ABLE MARINE ENERGY PARK (MATERIAL CHANGE 2 – TR030006)

UPDATED ENVIRONMENTAL STATEMENT

CHAPTER 4: DESCRIPTION OF CHANGES TO DEVELOPMENT & ALTERNATIVES

SLR Ref: 416.01148.00005
Version No: FINAL
June 2021

Scale:	Drawn By:	Checked By:	Approved By:
1:200@A1	D Almeida	R Crum	R Crum
Date:	03/12/2020	04/12/2020	04/12/2020
Drawing No:	AME-036-00003	Revision:	C

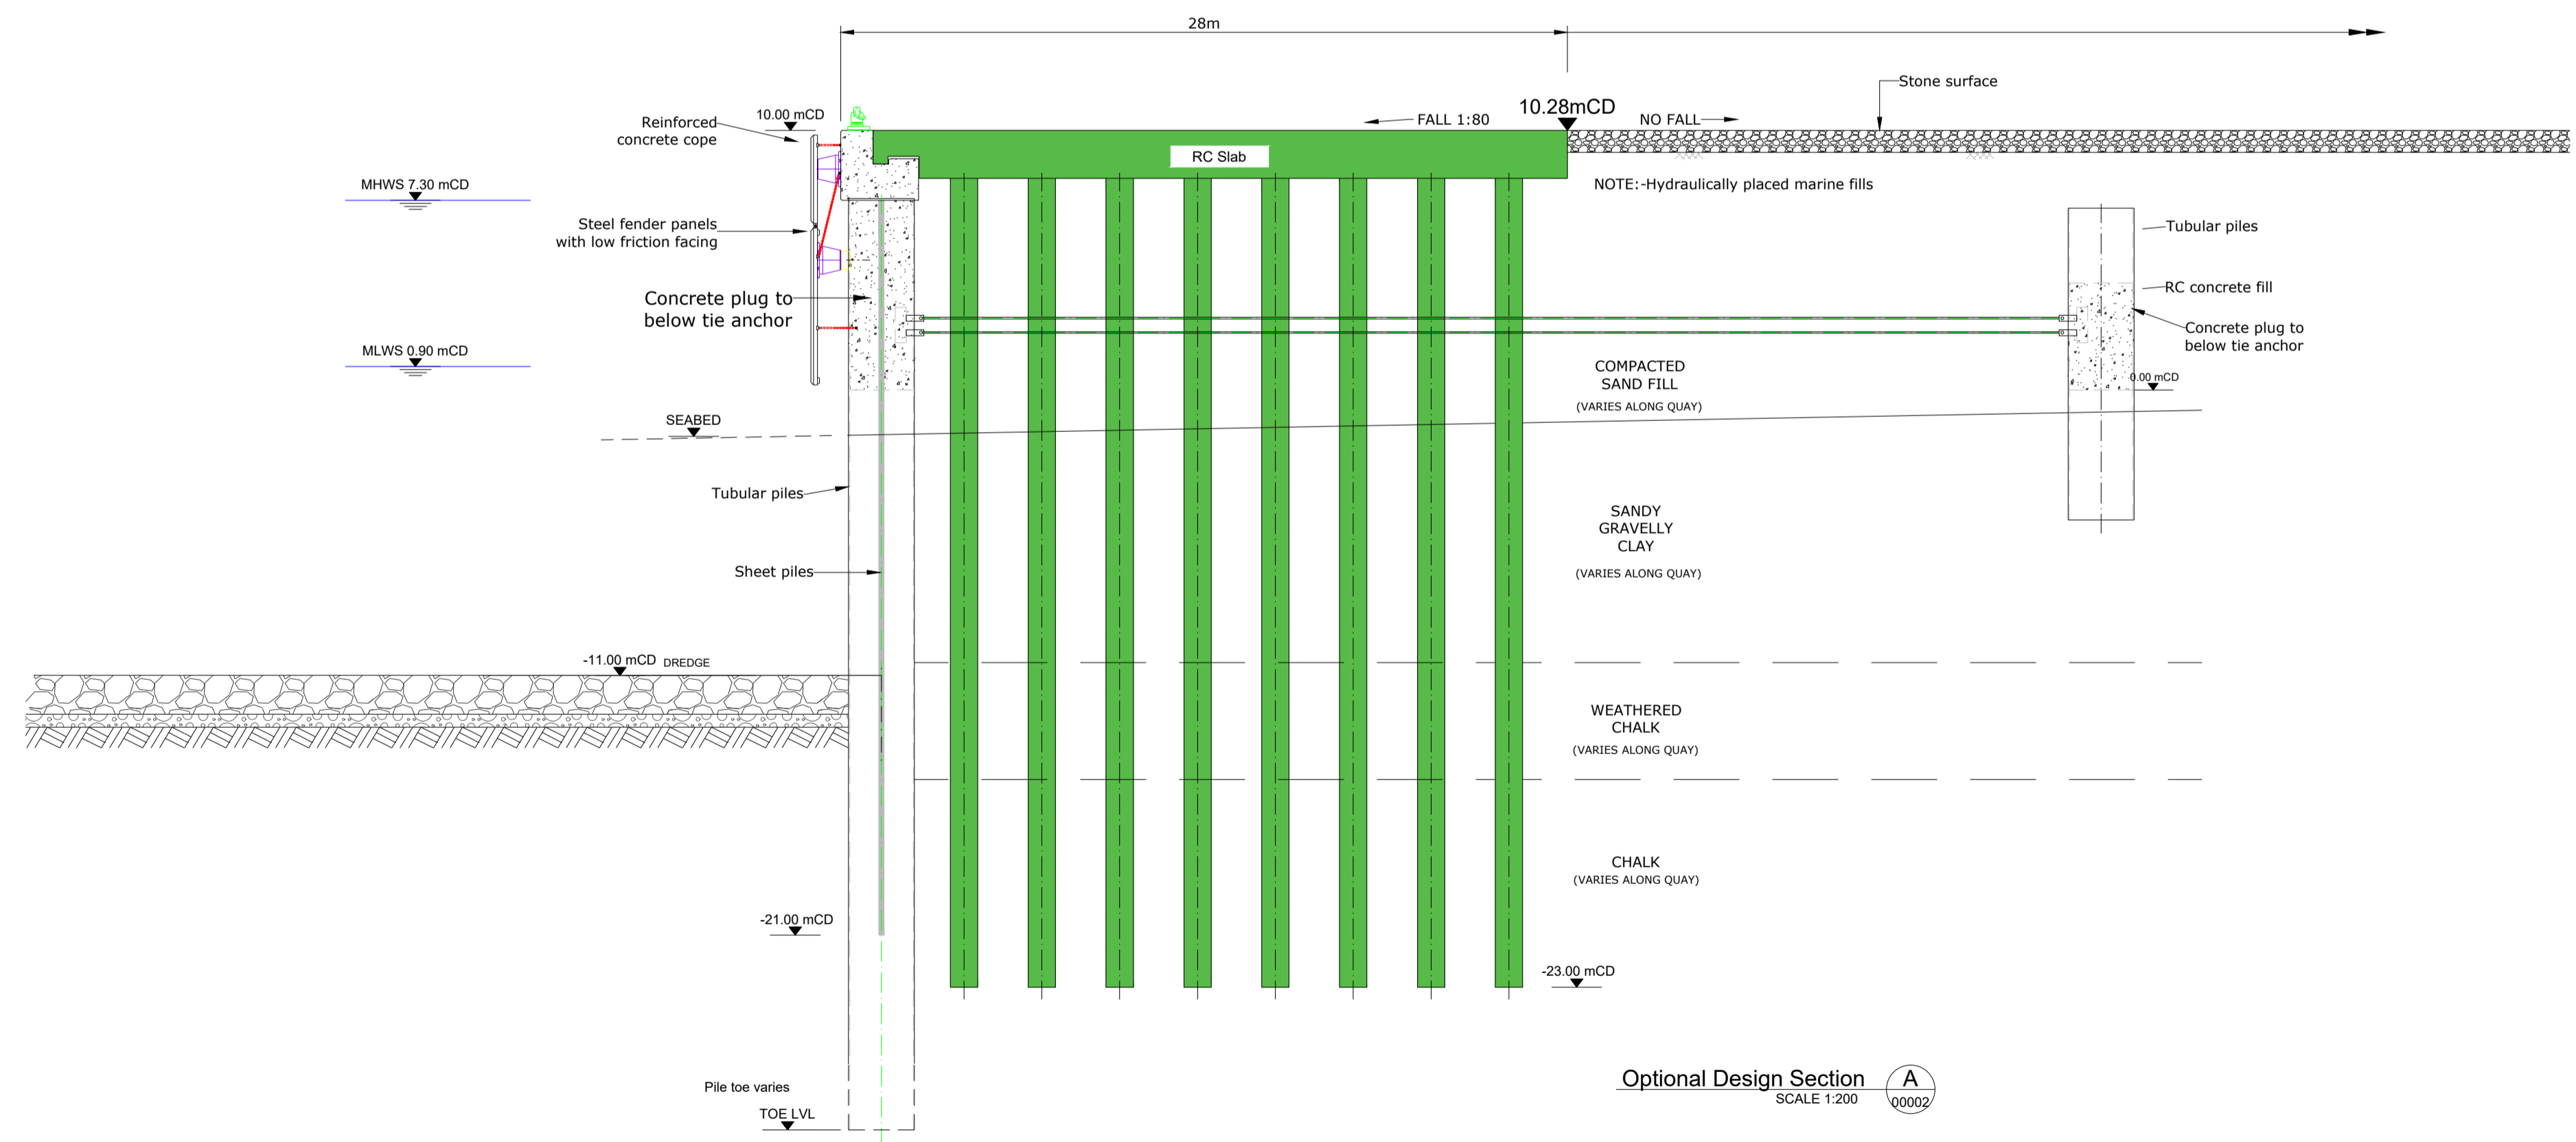
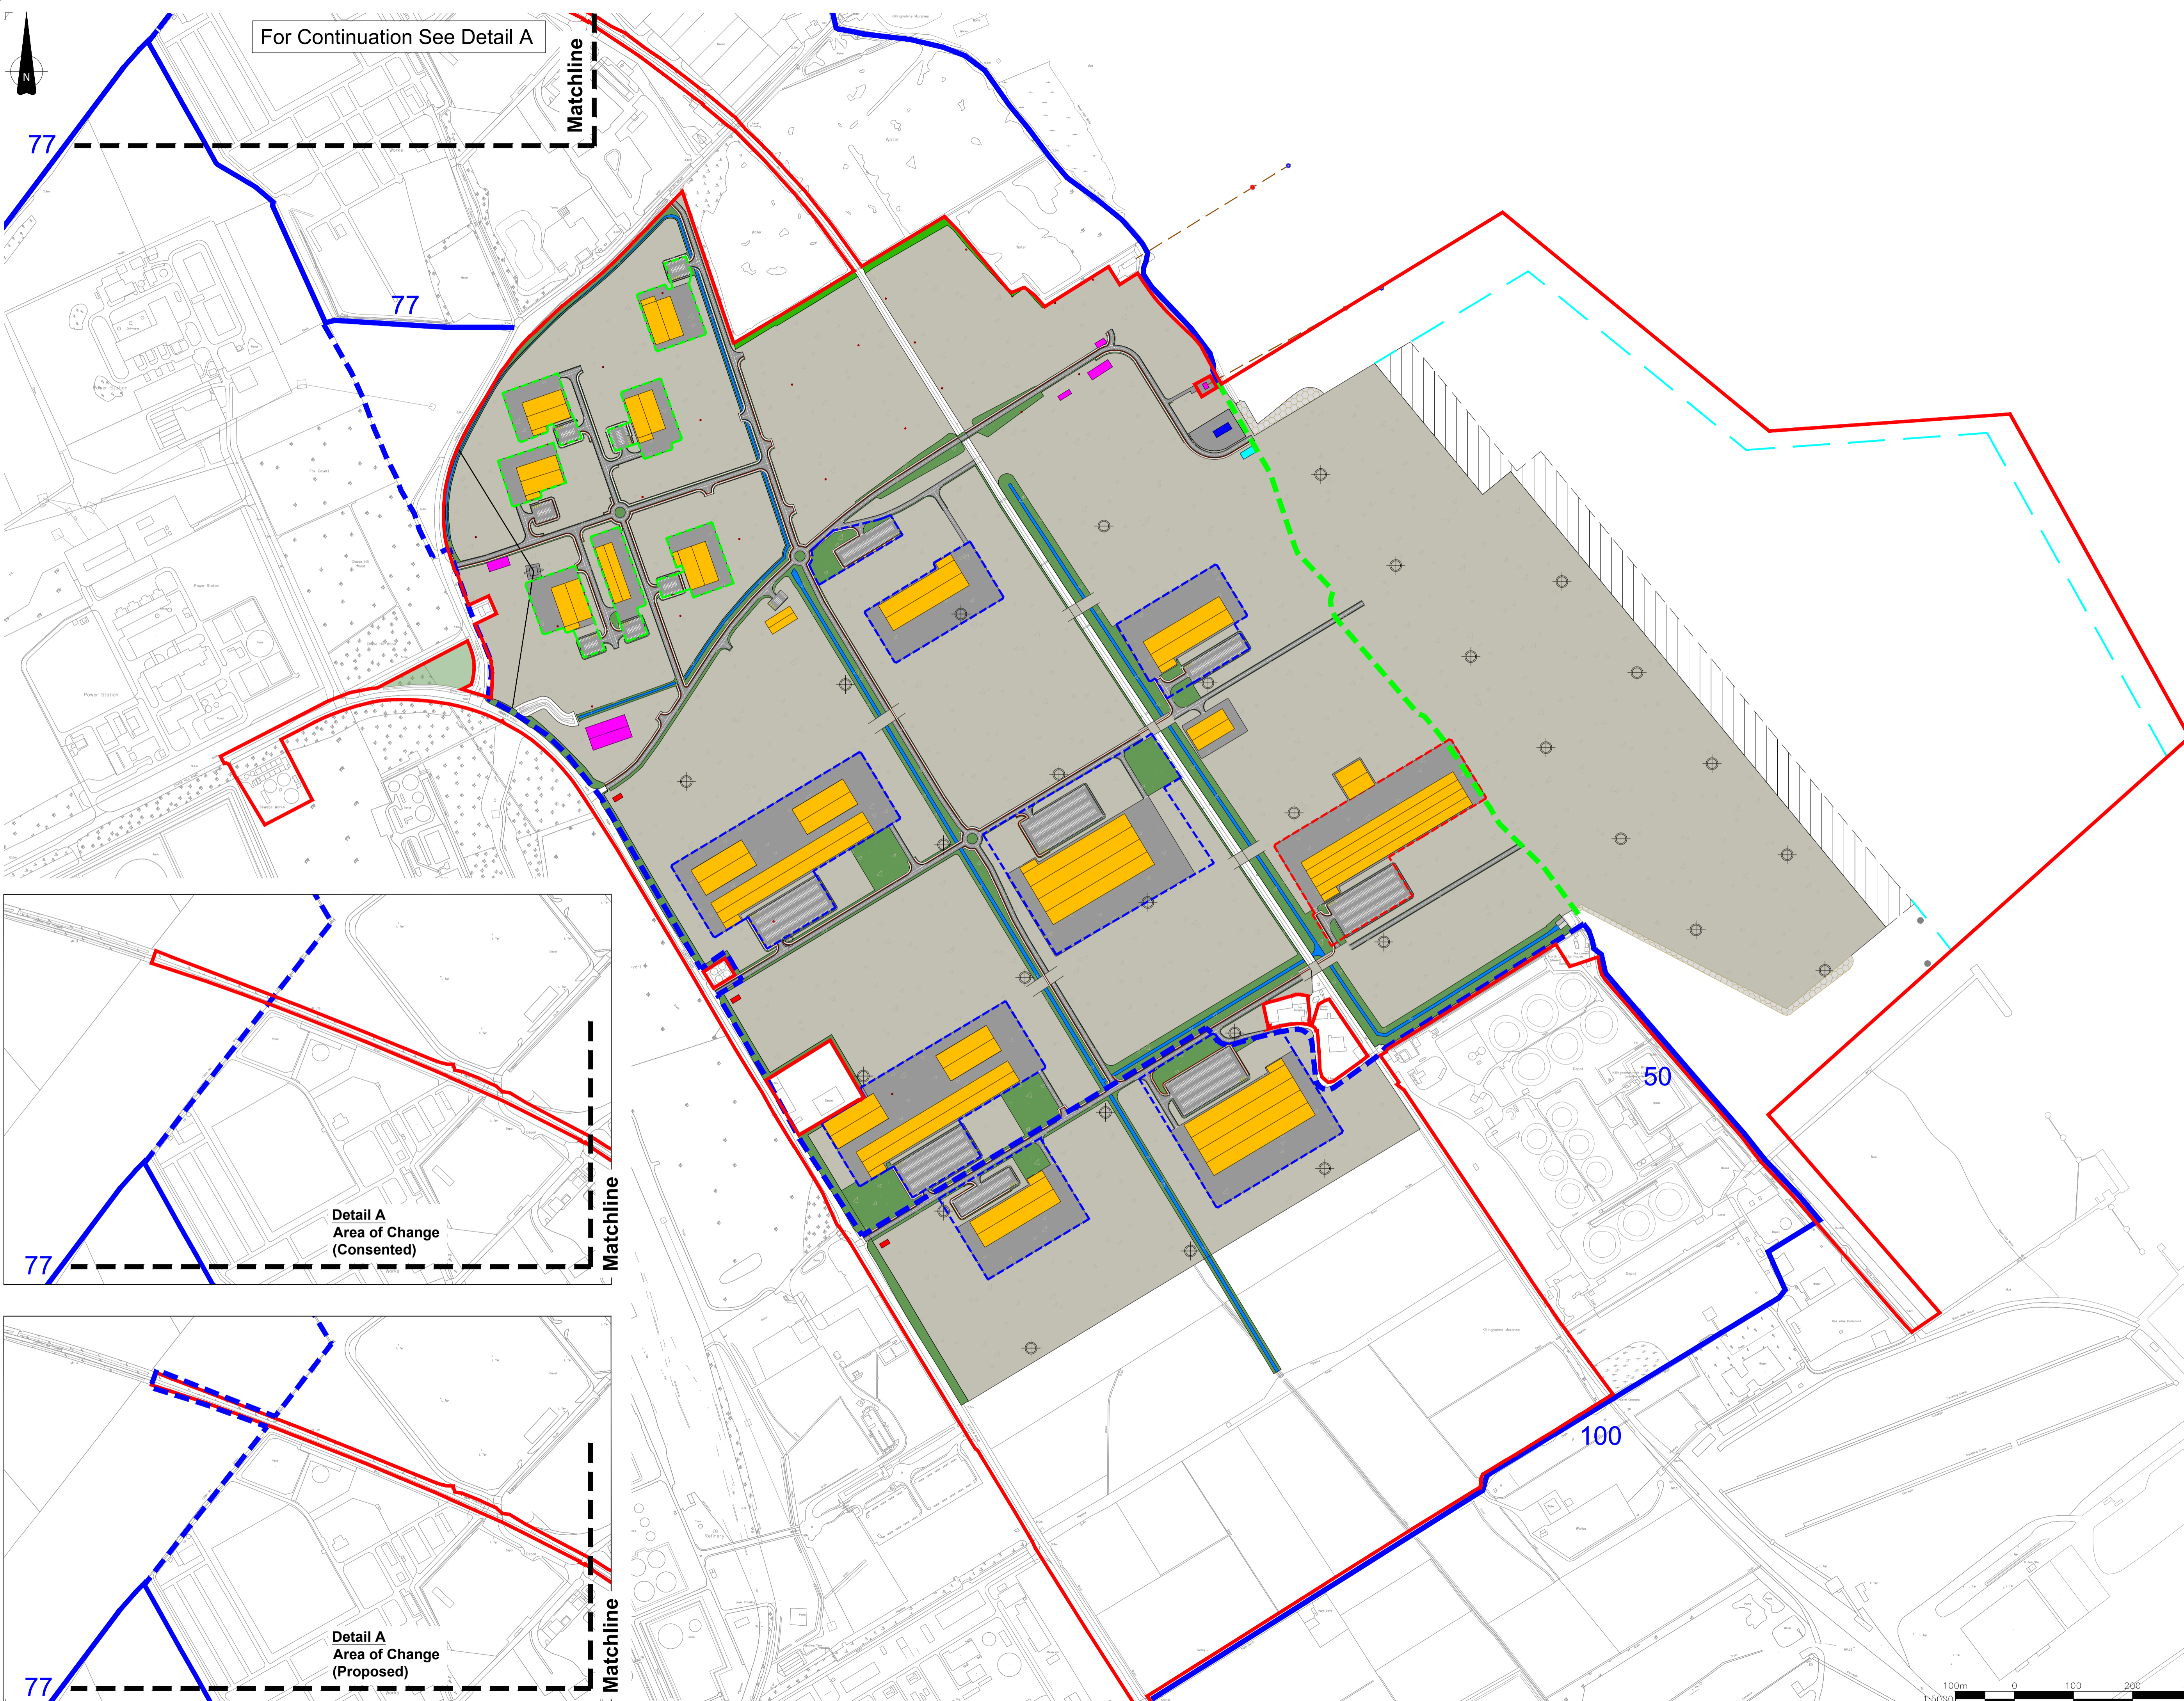
- c) Alternative details are proposed for the piled relieving slab to the rear of the quay which is shown on the approved drawing AMEP_P1D_D_003⁸. Options are sought to locate this slab at the ground surface, or it could be omitted altogether subject to detailed design, refer to drawing AME-036-00003 at Appendix UES4-1 which illustrates the alternatives being sought; and,

- d) Alternative details are proposed for anchoring the quay wall. The option is sought to use more conventional steel anchor piles and tie bars in-lieu of flap anchors to tie back the quay piles, but the option to use flap anchors will remain, refer to drawing AME-036-00003 at Appendix UES4-1.
